11 September 2018
Our Ref: 20550A.2ER_Submission

The Secretary
NSW Department of Planning and Environment
320 Pitt Street,
Sydney NSW 2000.

**Submission in relation to SSD 17_8876
Sydney Metro Pitt Street (South) Over Station Development**

Figure 6 – Pitt Street South Concept SSD DA – North South Section

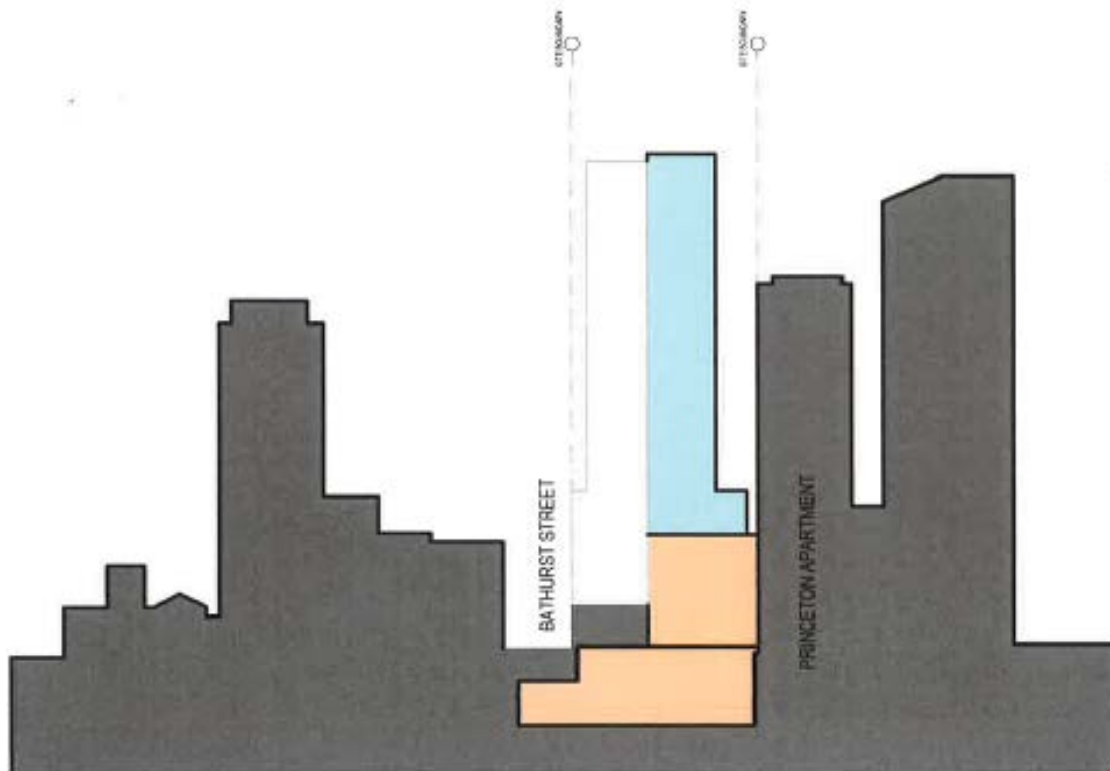
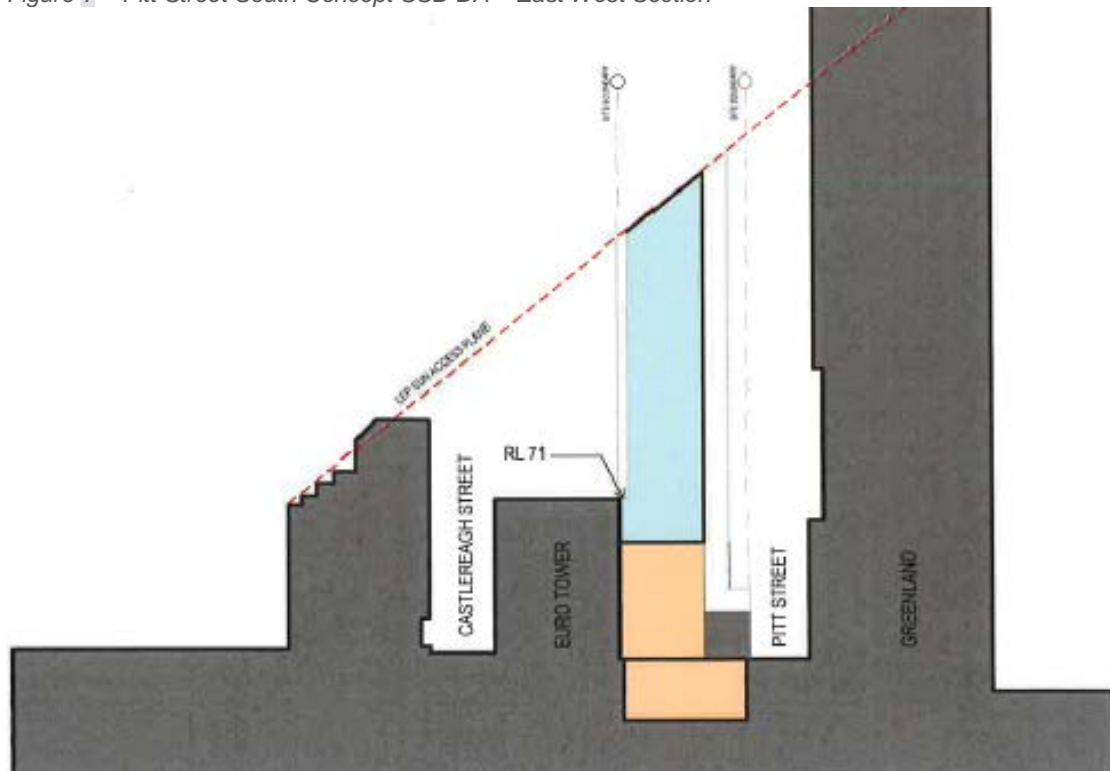
The plans submitted in relation to the concept scheme application propose a setback of 3m from the northern boundary of the Princeton Apartments site up to a height of RL71. Above RL71 the concept plans show a setback of 12m to the northern boundary of the Princeton Apartments site.

The architectural plans prepared for the application (Appendices D (residential option) and E (commercial option) do not include RLs therefore it is difficult to correlate the relationship of these setbacks from the Princeton Apartments building with the various residential levels within Princeton Apartments. Notwithstanding, it is considered that the setbacks proposed to the southern boundary of Lot 1 DP62668 are insufficient, particularly having regard to the objectives relating to the ADG building separation requirements.
